Response to Comments

Project Name: 163 RV Technical Review 1
 Project File Number: PA 23016
 Review Completion: October 2, 2023

A-1
 SHEET NUMBER

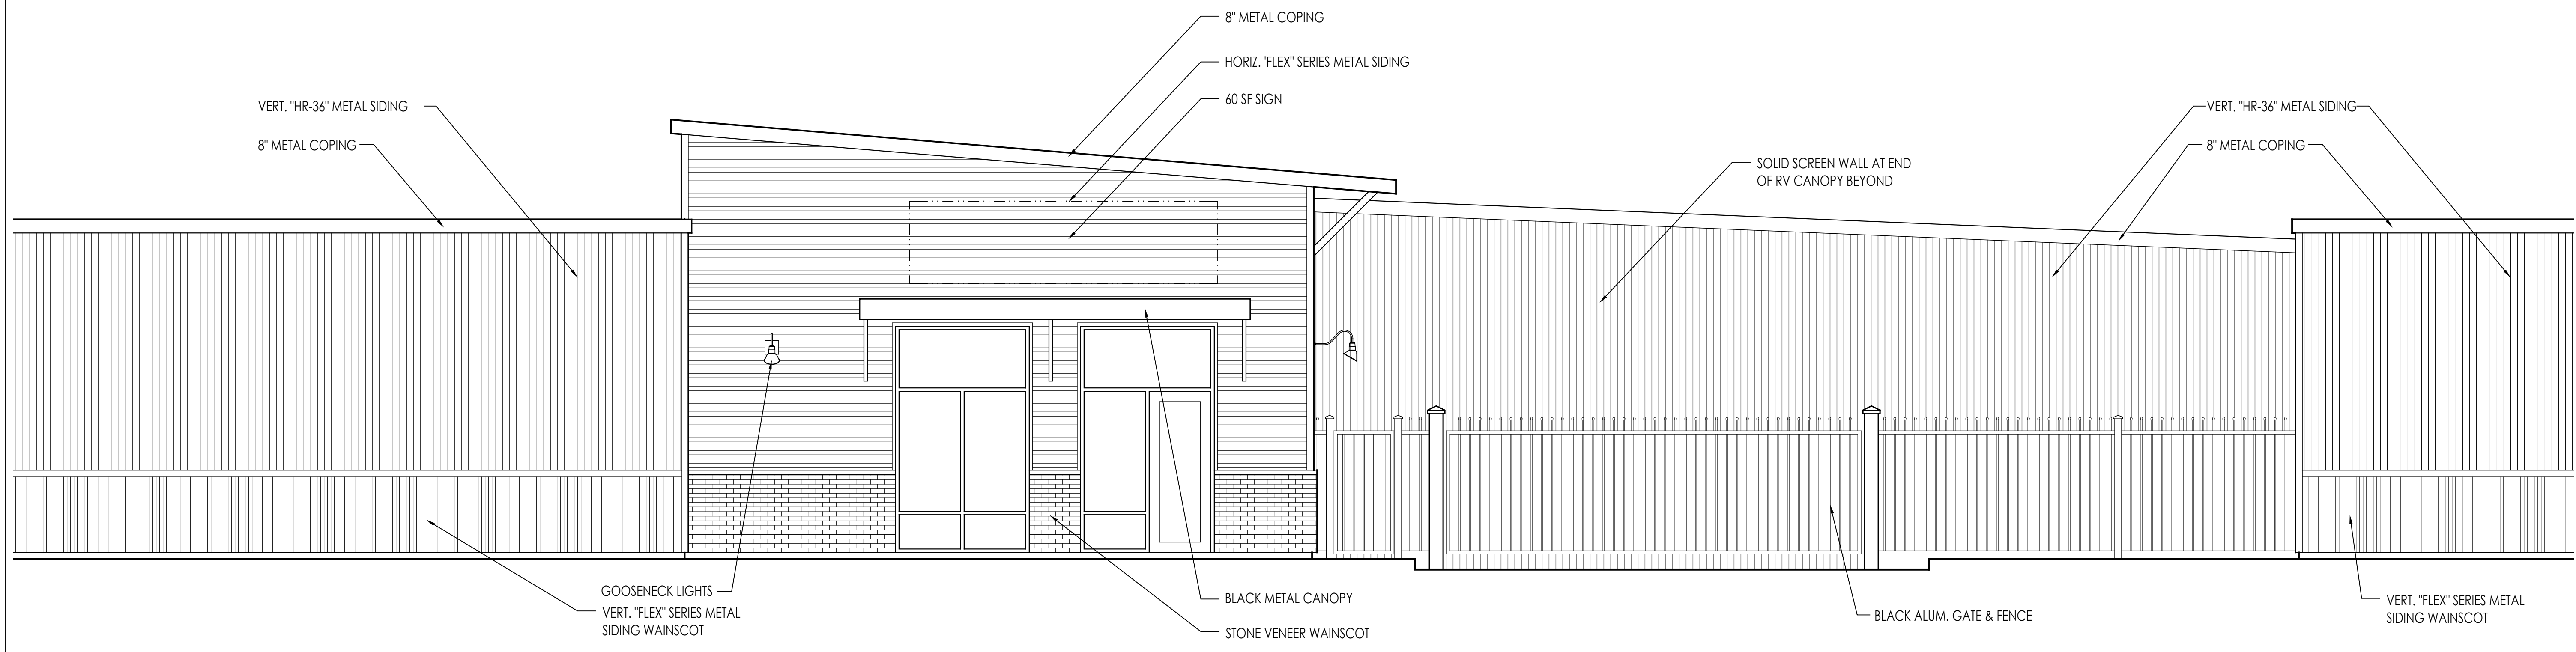
CITY COMMENTS	LAND TECH RESPONSE
Community Development-Planning Division: Reviewer: Chris Holland, Planning Manager	
1. Provide File Number PA23016 on all future site, civil and landscape plan submittals.	File Number PA 23016 has been added on drainage report and civil plans.
2. A preliminary critical areas enhancement and mitigation plan, designed in accordance with MMC Chapter 22E.010 Critical Areas Management , shall be required to be submitted.	Buffer Mitigation plan is provided from Wetland Resources. See "Buffer Restoration Plan 163 RV Storage"
3. A Natural Growth Protection Area Easements (NGPAE) shall be required to be recorded, prior to granting occupancy permits.	Understood
4. A preliminary illumination plan, designed in accordance with MMC 22C.130.050(3)(d) , shall be required to be submitted.	See Architectural Site Plan A-1 for Preliminary Lighting Plan.

**CIVIL SITE PLAN**

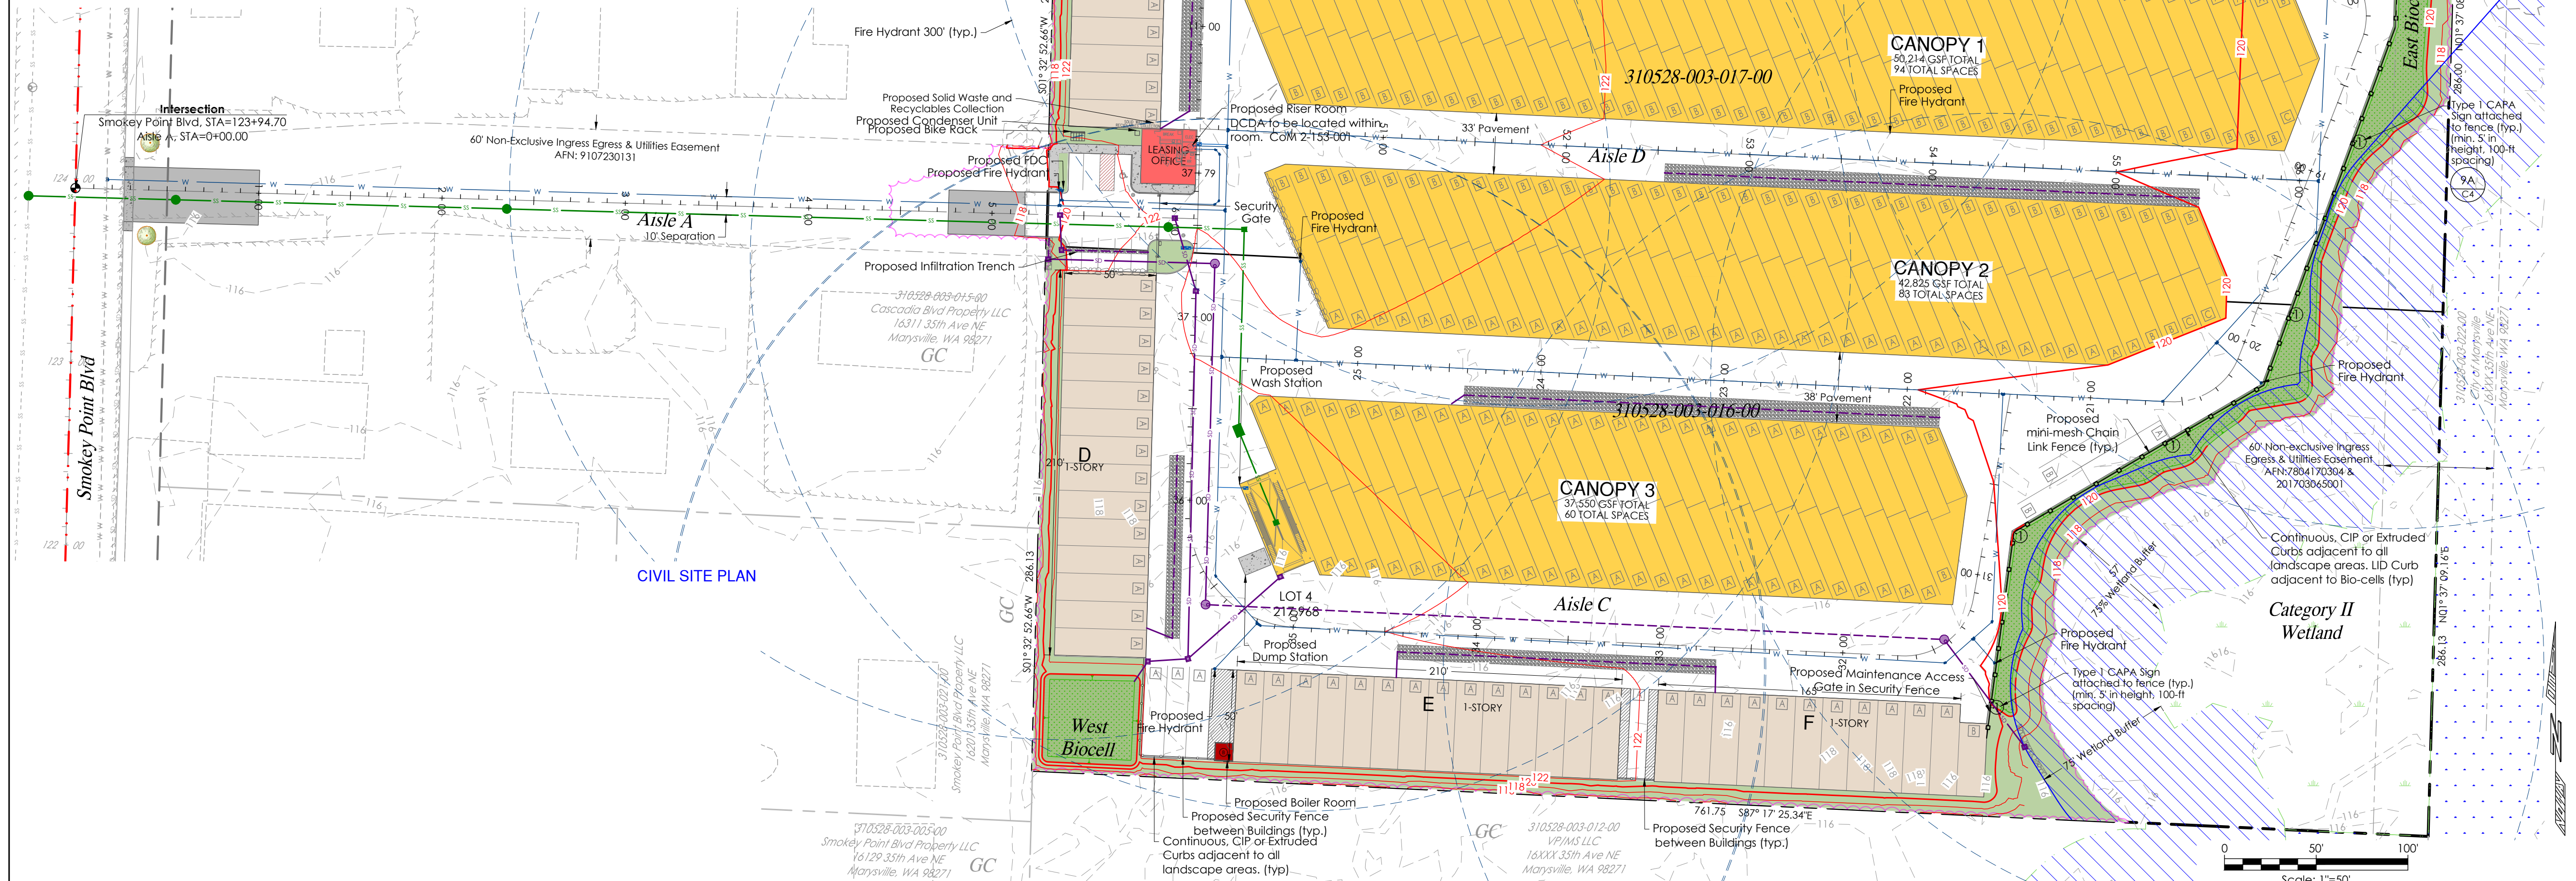
CITY COMMENTS	LAND TECH RESPONSE
<p>c. Provide a detail of the proposed fencing on the site and civil plans. Fencing is required to be low-maintenance material and articulation at intervals no greater than 20 feet.</p> <p>d. Security fencing is proposed adjacent to the critical area buffer; therefore, the split rail fence can be eliminated. NGPA Fencing signs shall be required to be placed on the security fencing and spaced 1 per 100 feet.</p> <p>e. Pursuant to MMC 22C.170.040(h)(i)(B), the area devoted to outdoor storage is less than 50 percent of the footprint of the storage building(s). Provide this calculation on the site plan.</p>	<p>currently using the existing road. This proposed project 163 RV site also was denied access to the Regional System and would be a conflict to say there is room for the adjacent site. Update, there is not room in the Regional System.</p> <p>The only way to sensibly develop the road requested, would be with the re-development of the site. The site is available for purchase (price currently a little too high) with an interested buyer. With most new Owner's, this site will be redeveloped to higher and better use.</p> <p>A specification for our proposed tamper-proof fencing has been provided with this submittal.</p> <p>Good call, split rail fence callout has been dropped.</p> <p>Outdoor Storage along with the Canopy Areas will exceed the 50% criteria. The Covered Canopy RV storage areas are nearly 3 times the totally enclosed areas. Calculations shown on P1 of site plans.</p> <p>However, the enclosed storage areas do provide a perimeter screen of these canopy areas. Walls are being added to the west and east end of the canopy RV storage areas to further block views to an Open Storage. Per MMC 22C.170.040(1)(h)(i)(A), outdoor storage of boats or recreational vehicles, when a solid screen is provided, so outdoor storage is not visible from abutting properties can be allowed.</p> <p>Elevations of the canopies and these end walls to be provided by architect.</p> <p>This is an RV Storage project trying to adopt the Code written for mini-storage facilities. There are several incongruencies in trying to make the adaptations.</p>

SEWER AND WATER OVERVIEW PLAN

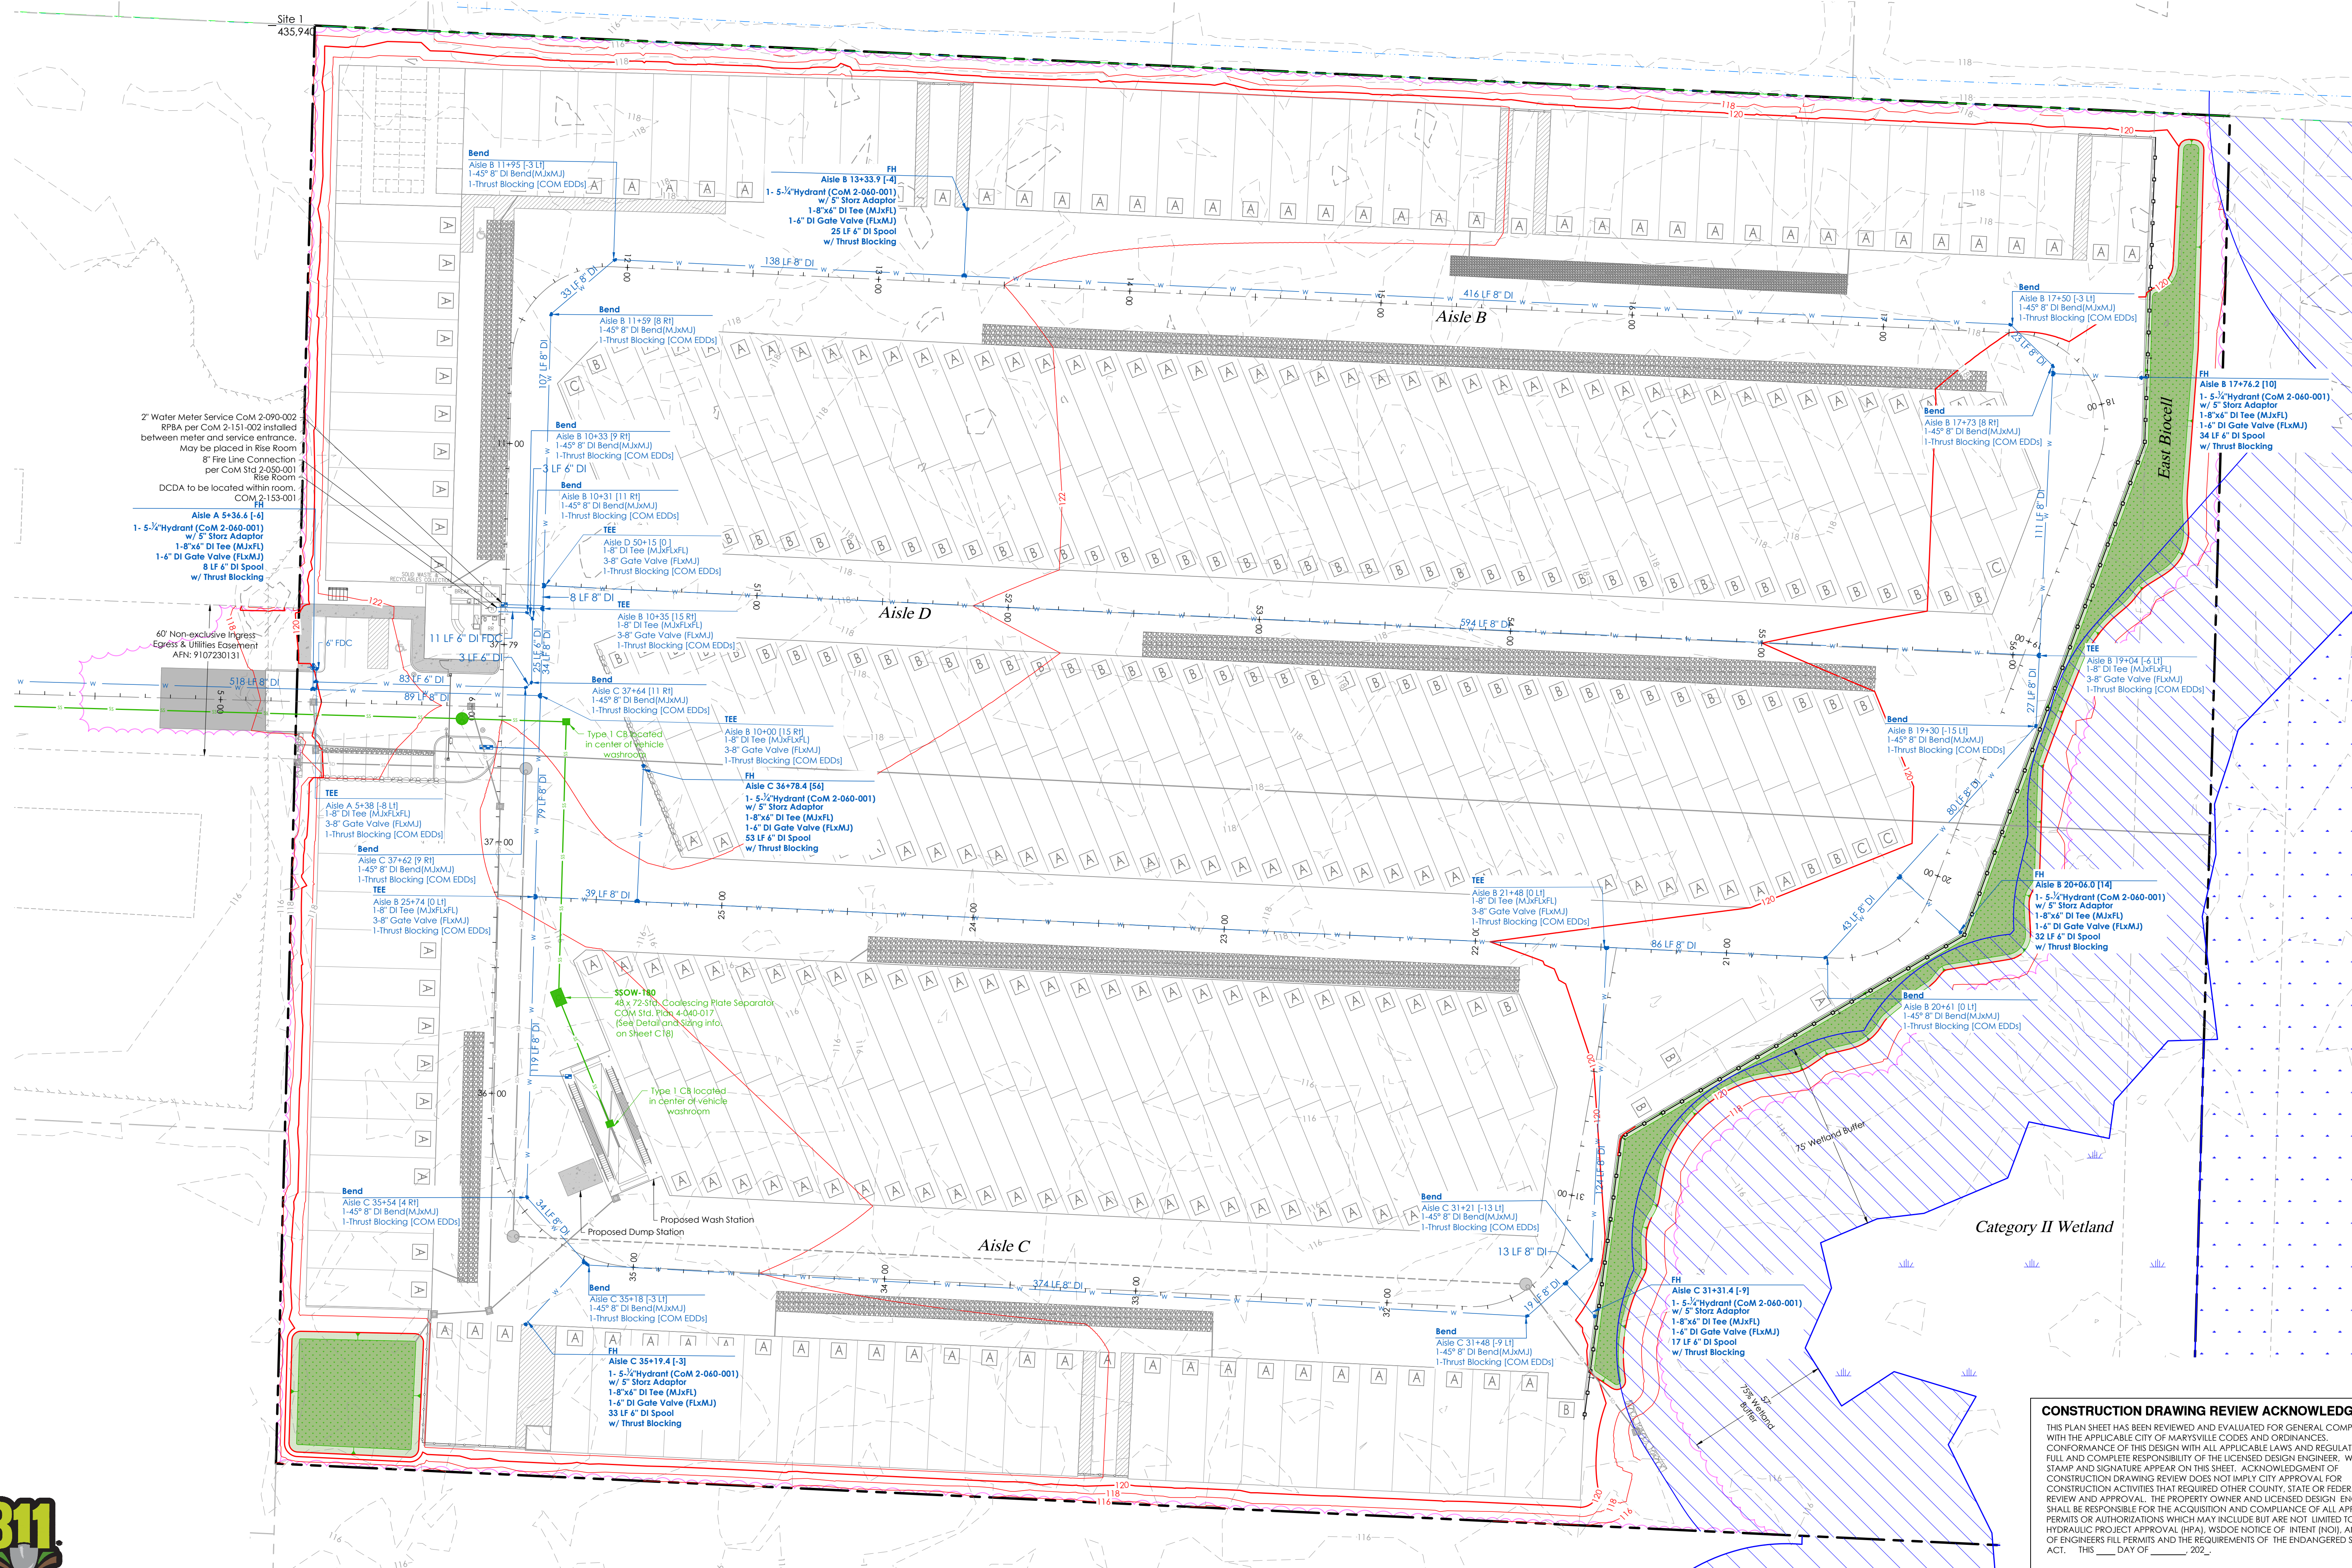
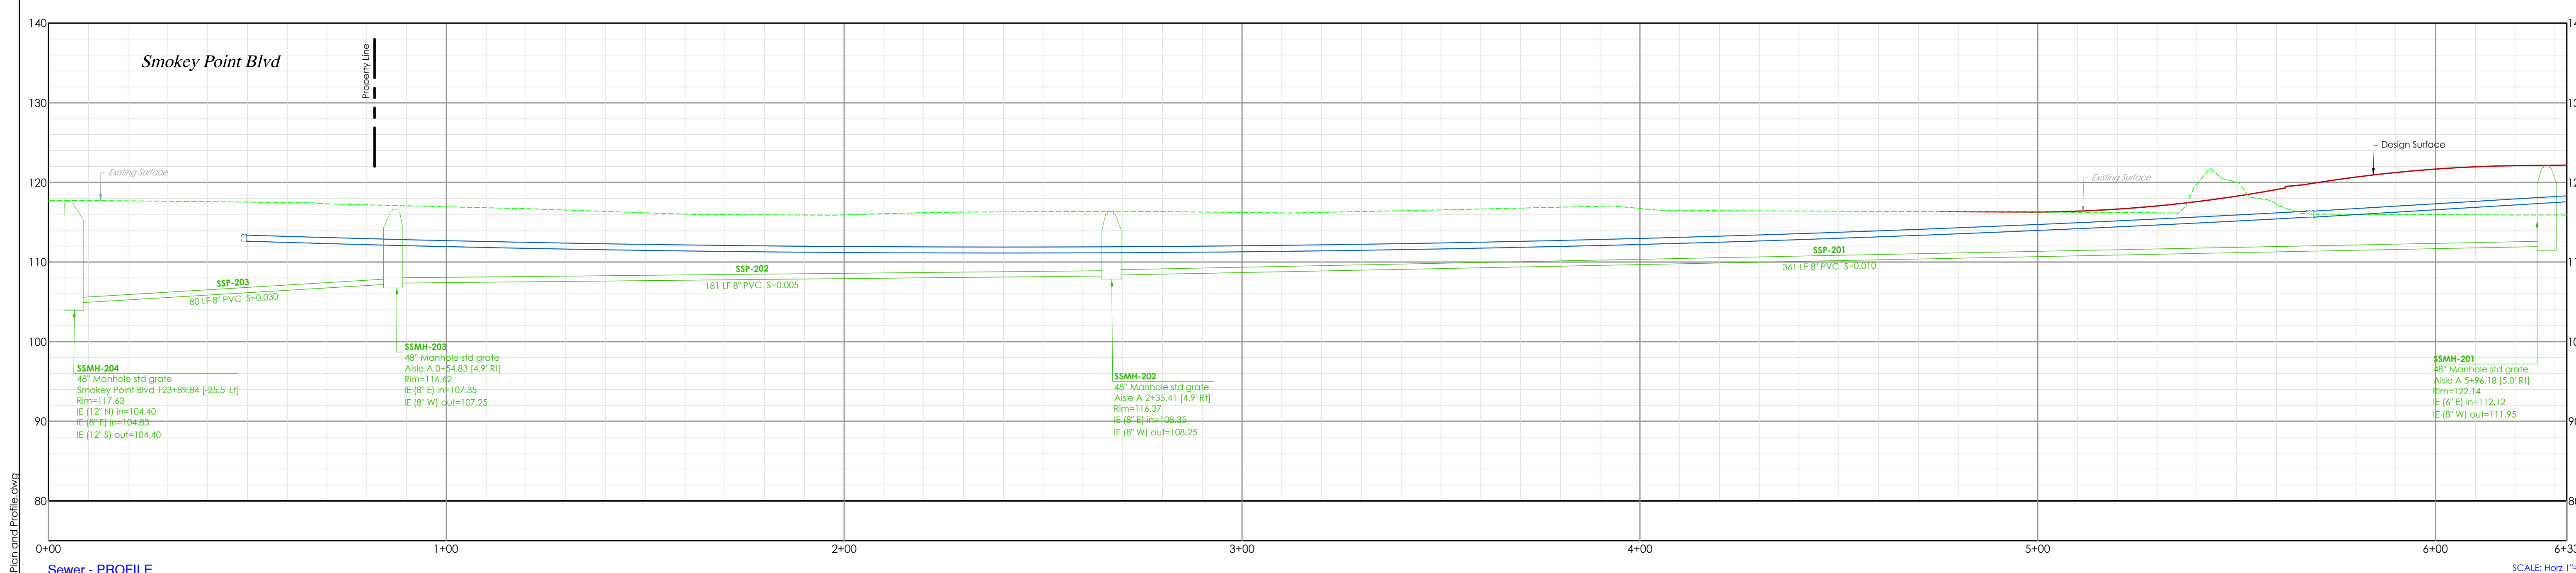
CITY COMMENTS	LAND TECH RESPONSE
Fire District: Reviewer: Don McGhee, Assistant Fire Marshal	
45. The water plan shows an 8" DI water main extension to the site with one hydrant at the entrance into the storage yard. The plans do not show the water line loop or hydrants within the storage yard.	Loop and Hydrants added.
